Please ask for: Ms Iqraa Malik
Email: iqraa.malik@terraquest.co.uk
Telephone: 0121 234 1390
Our Ref: EP/123/21/HH
Your Ref:
Date: 7th October 2021

Application for Planning Permission for Works or Extension to a Dwelling

Development: Erection of single storey side extension following the demolition of existing garage
Location: 22 Normandy Lane East Preston BN16 1LZ

BLOCK PLAN 1:200

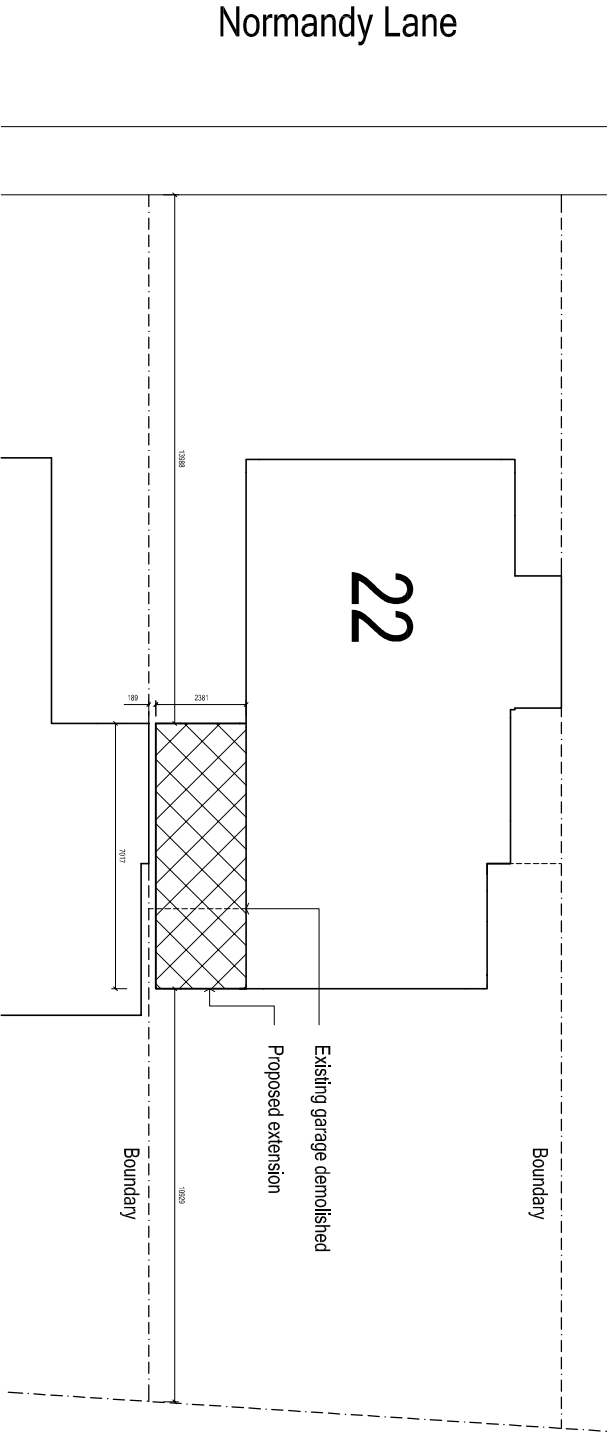
Please amend the block plan to include the dimension from the proposed extension to the front boundary. Further details of what must be included on the plan can be found in the Validation Requirements List.
